**UNIVERSITY OF SYDNEY
AUSTRALIAN INSTITUTE OF
NANOSCIENCE**

ACCESS REVIEW

Morris-Goding Accessibility Consulting

4 July 2013

drawing
Proposed - West Link and East Link
Plans

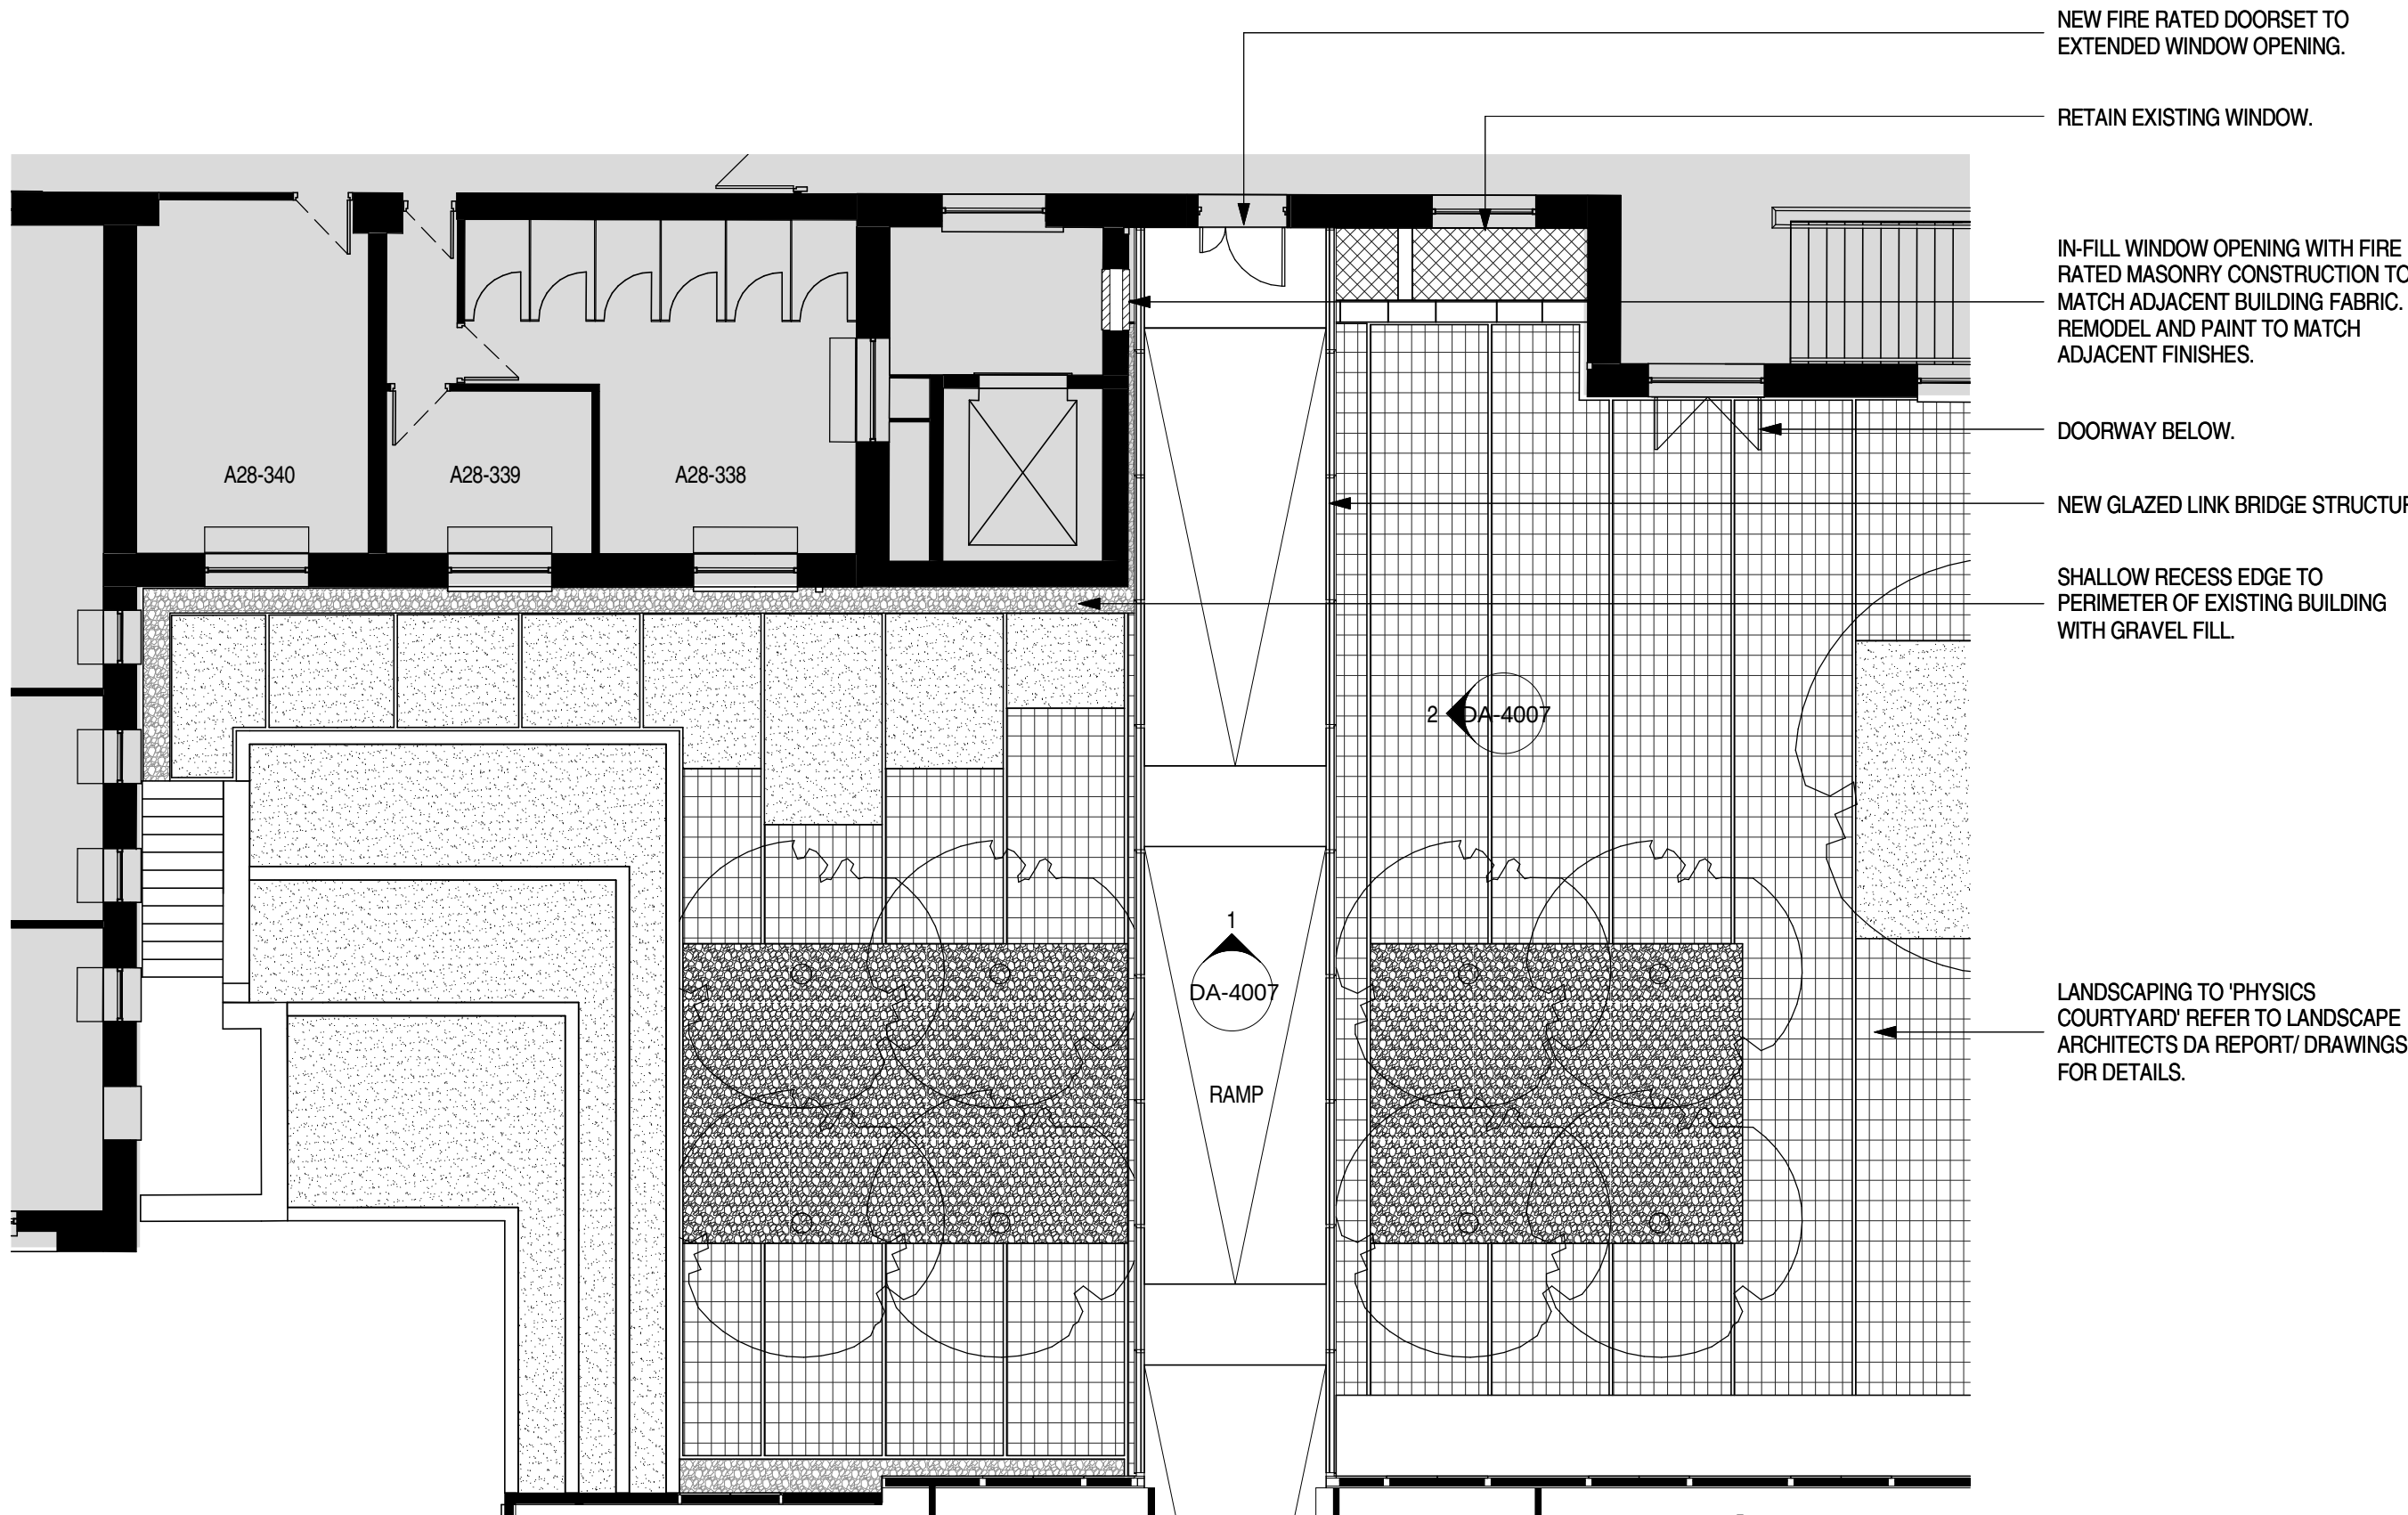
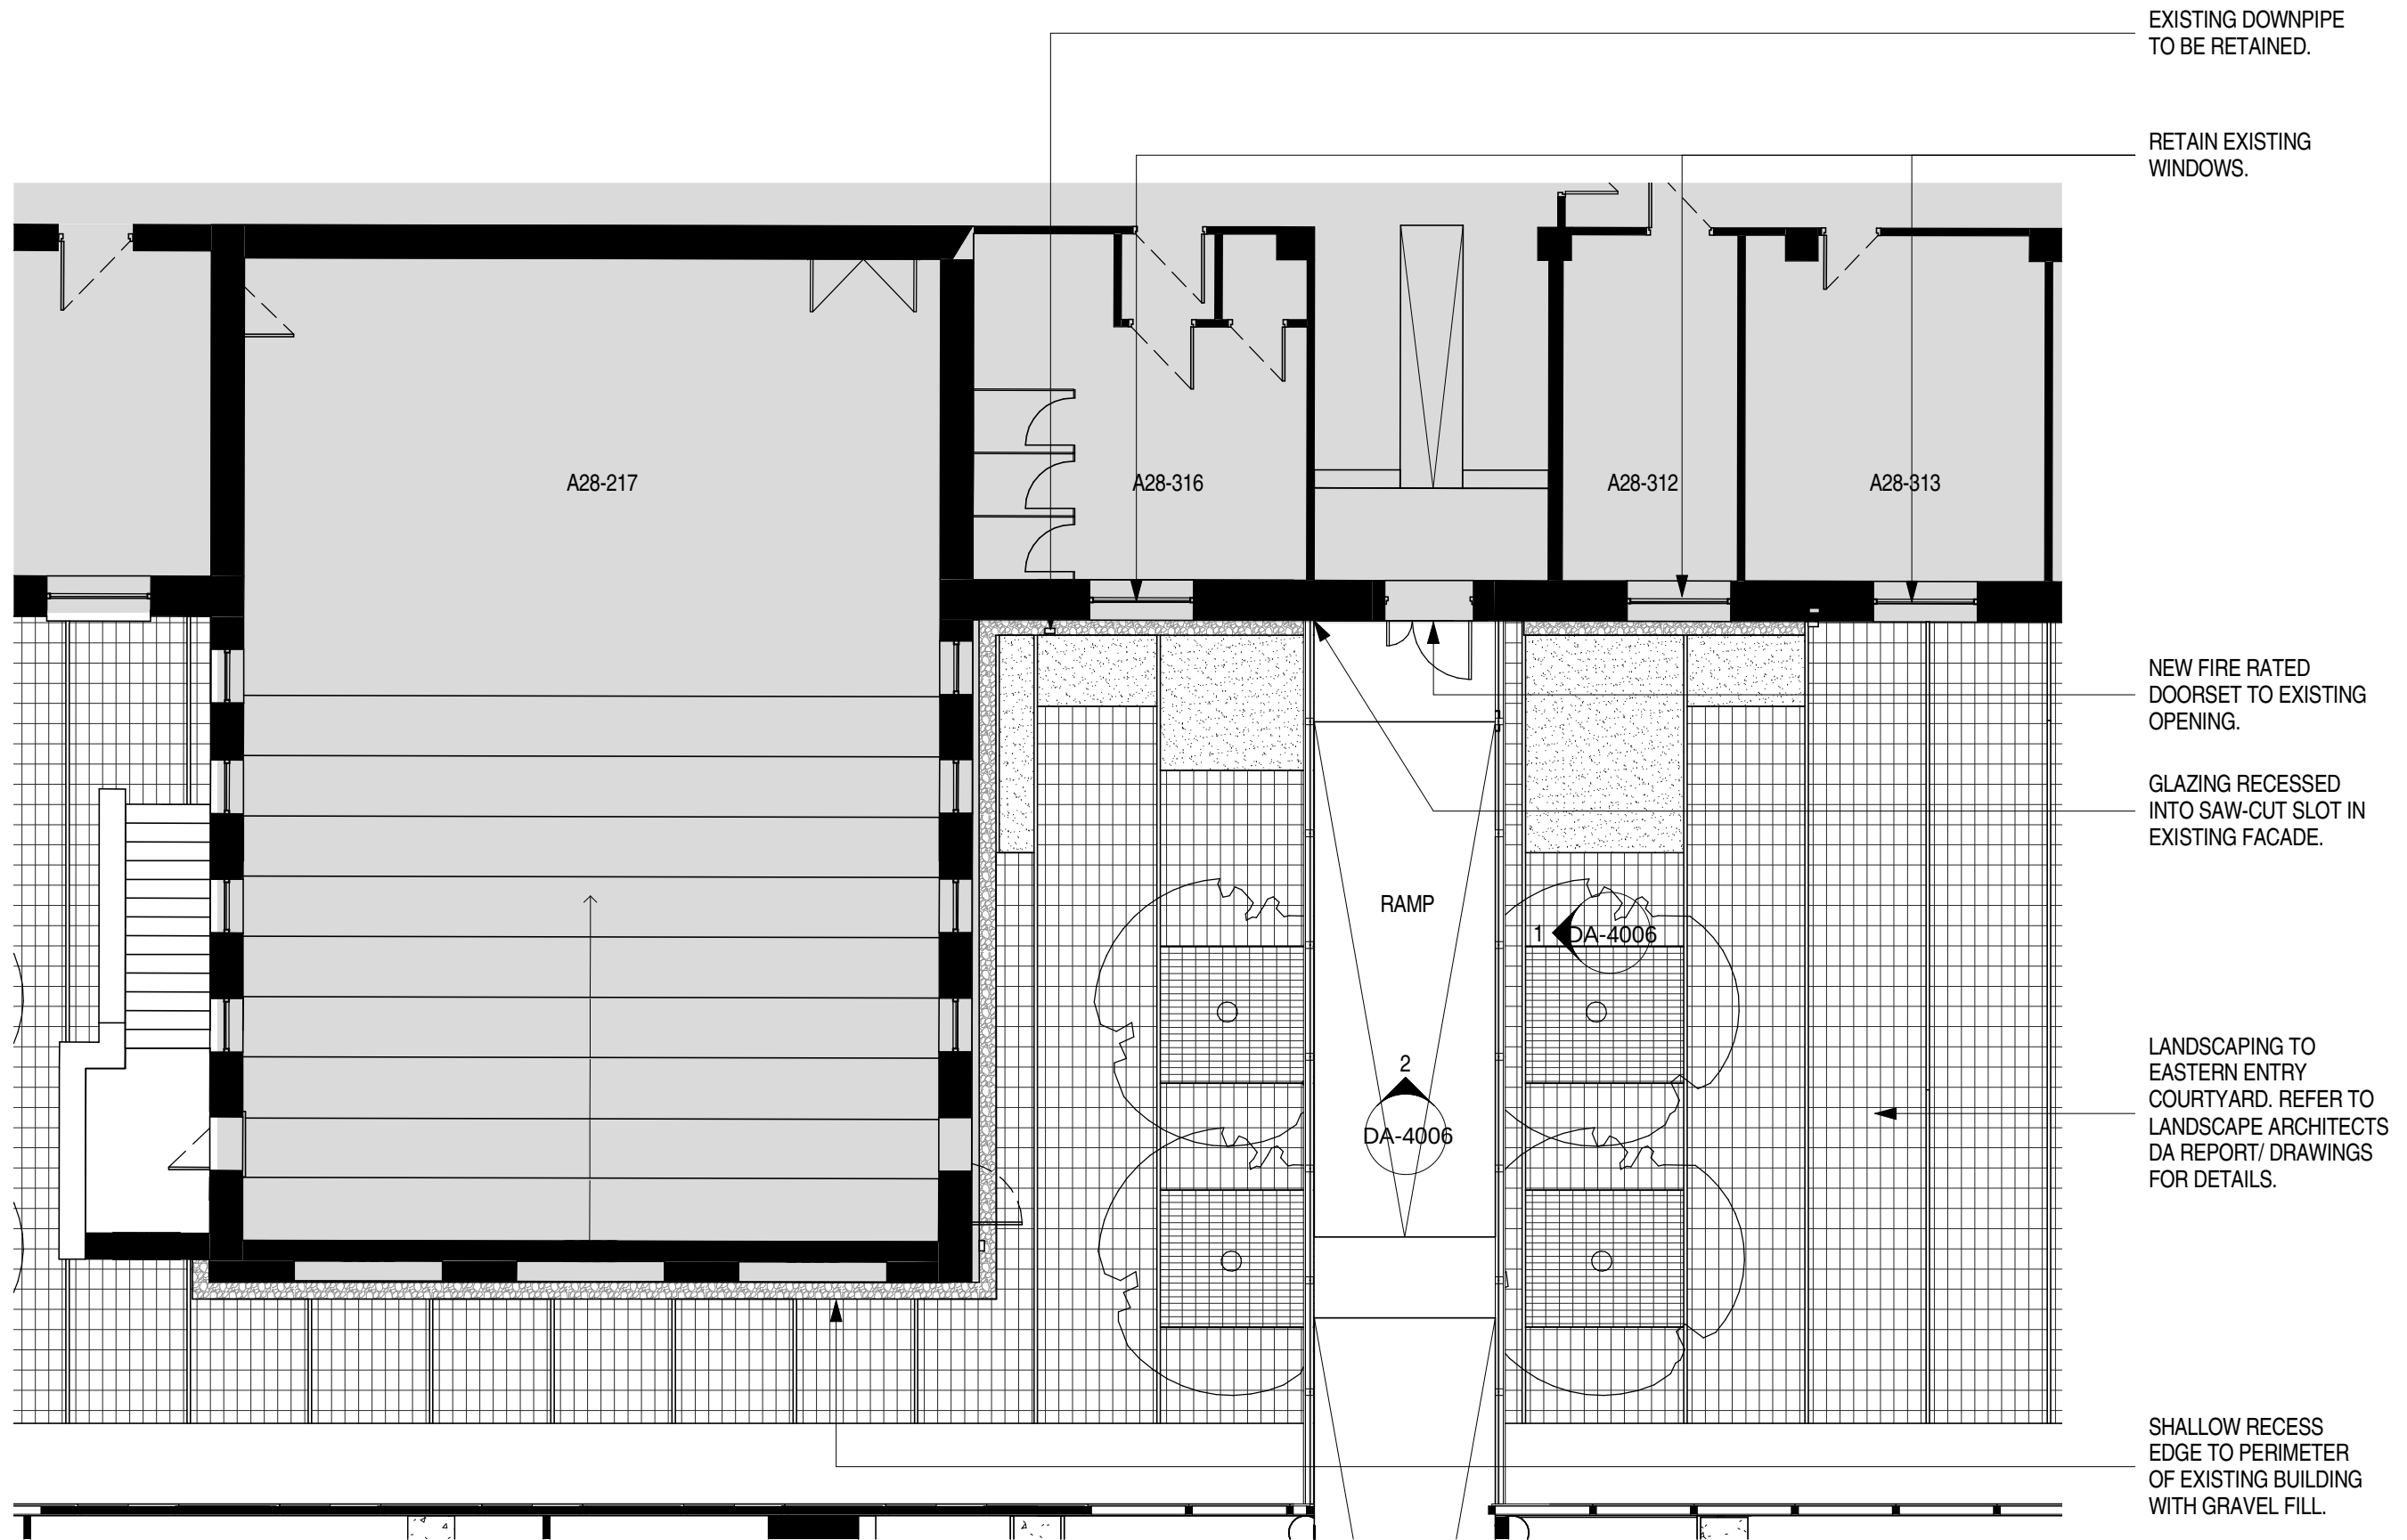
There are two pedestrian bridge linkages provided between level 2 of the existing Physics Building and the 2 of the new development.

In general, the pedestrian bridge linkages provide a continuous accessible path of travel between the two buildings, compliant with BCA and DDA Premises Standards.

The 1:14 ramps used have a length of no more than 9 metres and landing areas, in accordance with AS1428.1-2009. The doorways to the existing Physics Building have sufficient door circulation areas, in accordance with AS1428.1-2009.

The ramps across the pedestrian bridge linkages have a sufficient clear opening width, in accordance with City of Sydney Access DCP 2004.

drawing Floor Plan - AIN Level 3

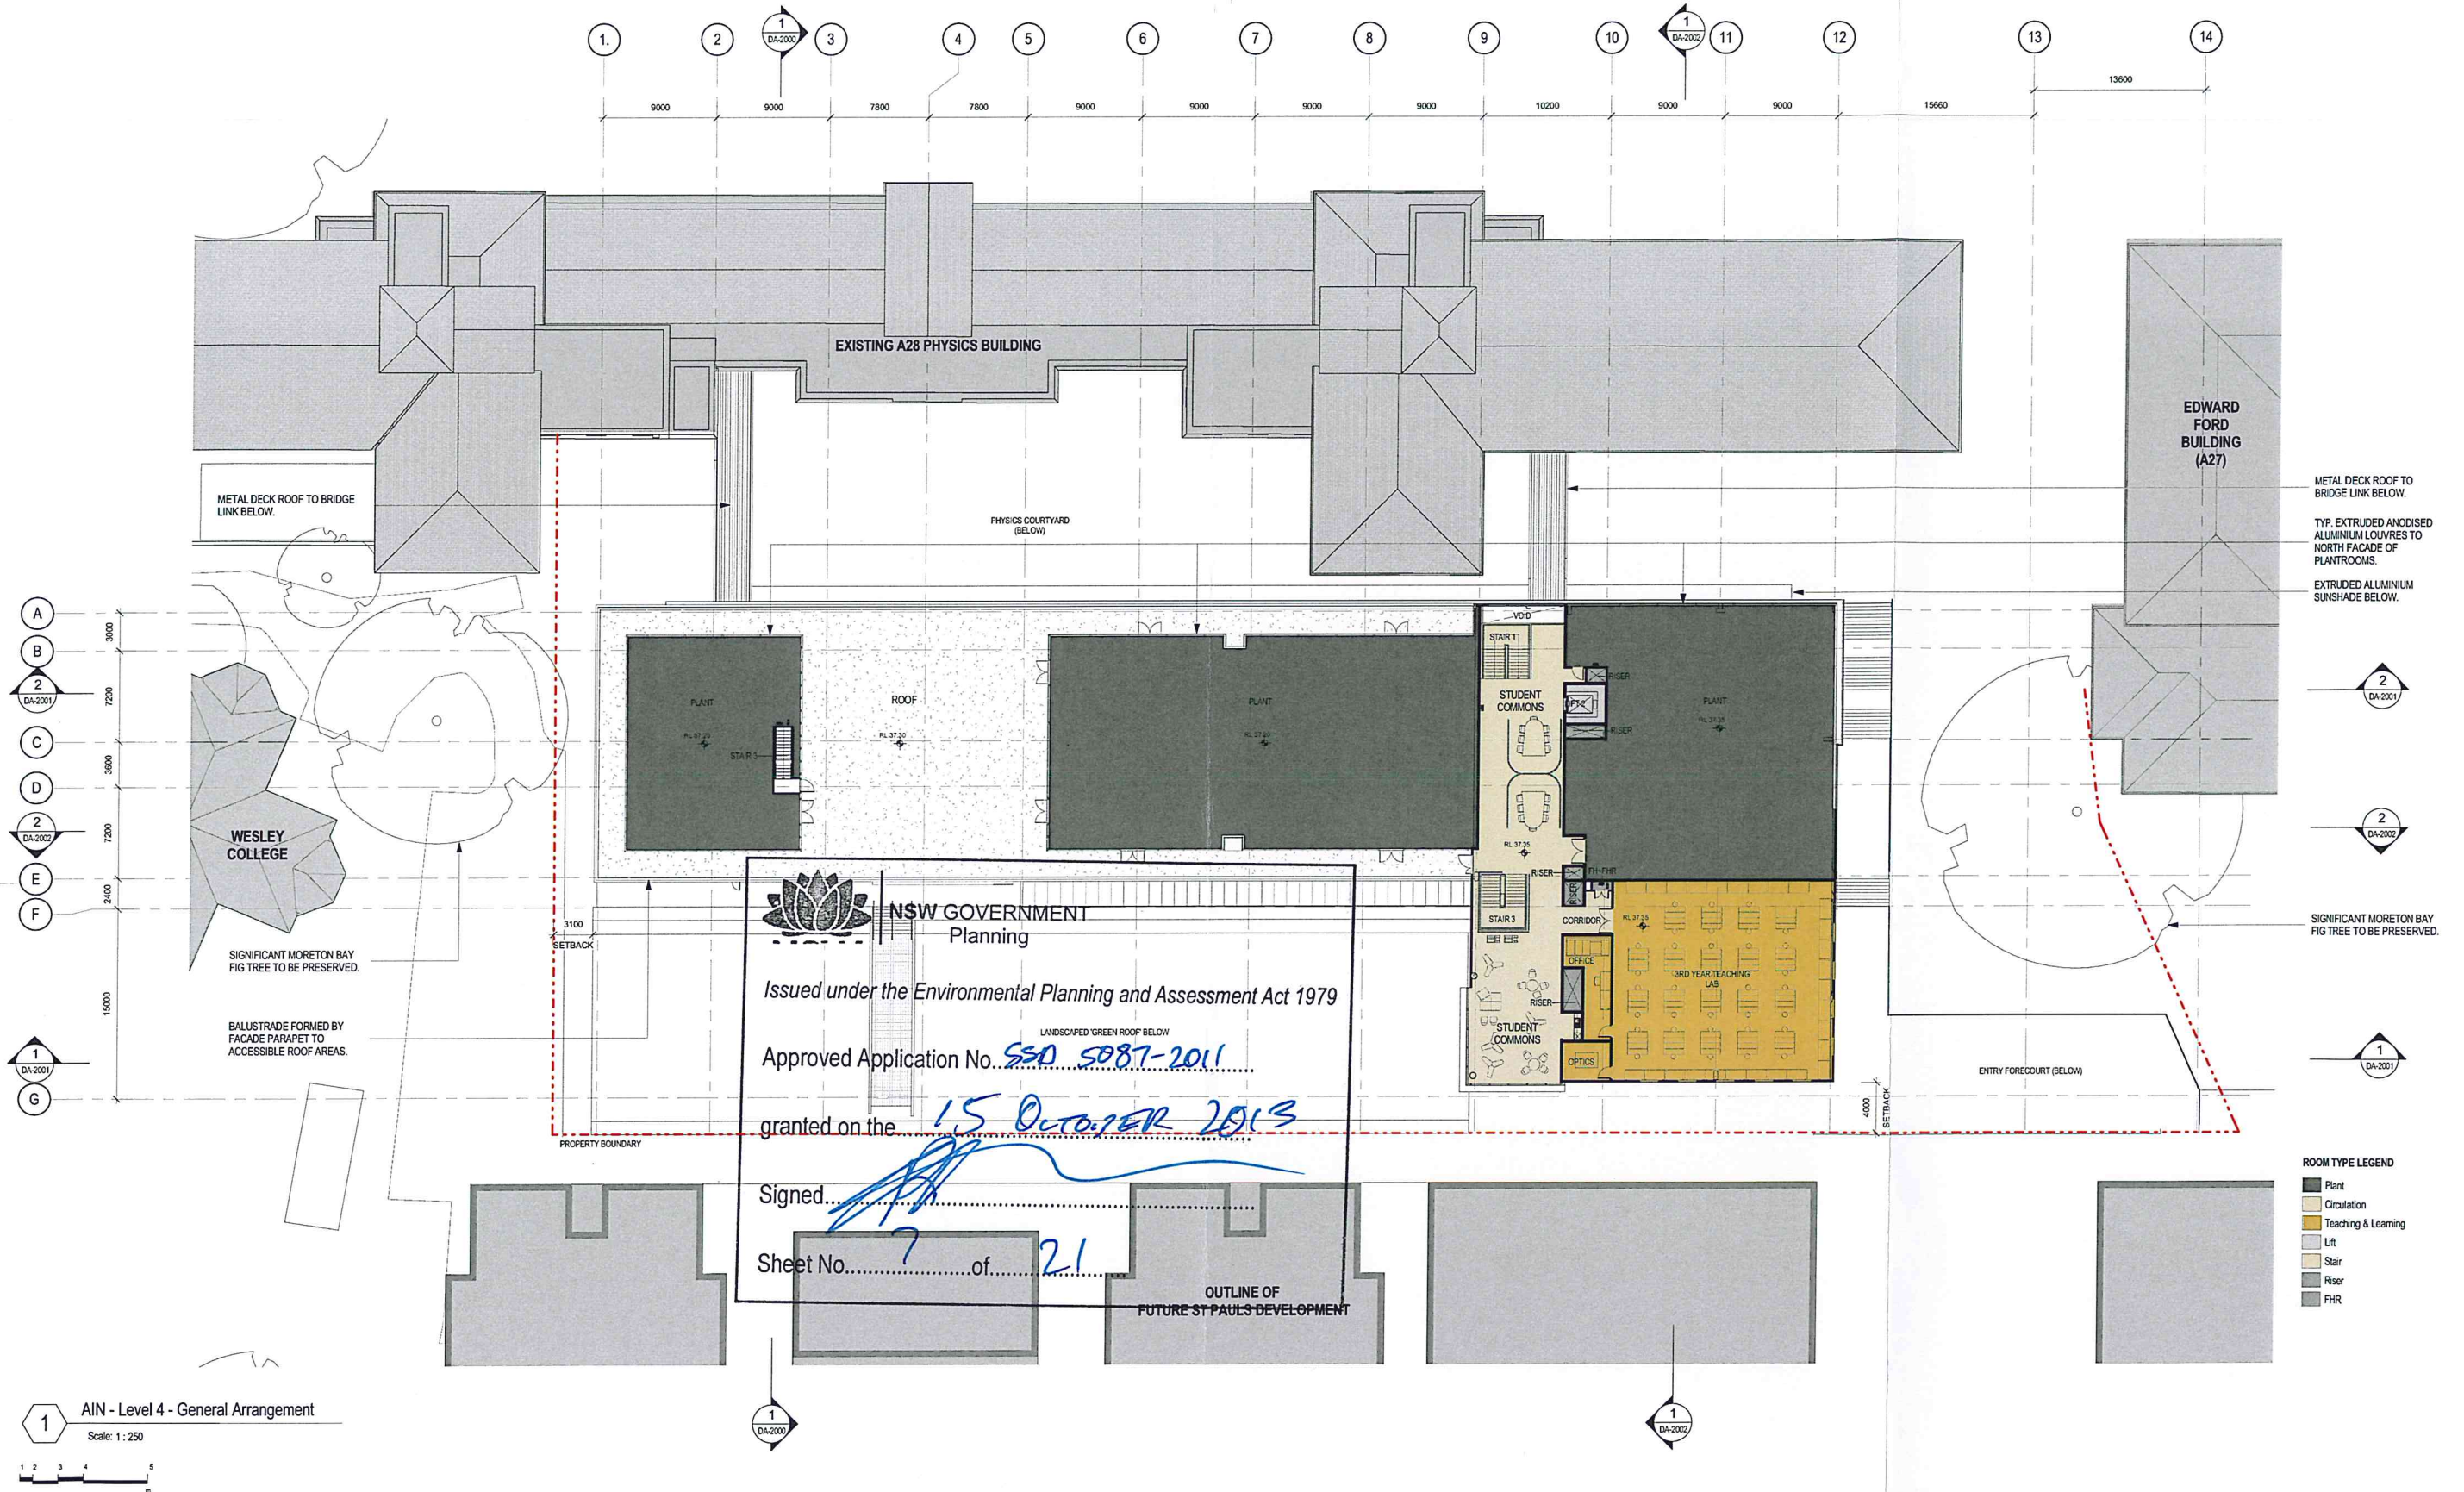
There is a Student Commons area provided on level 3 of the building. In general, there is a continuous accessible path of travel to and from the area, in accordance with AS1428.1-2009.

The Student Commons area consists of sufficient circulation areas for a person in a wheelchair to make a 180° turn in an equitable and dignified manner, in accordance with AS1428.1-2009.
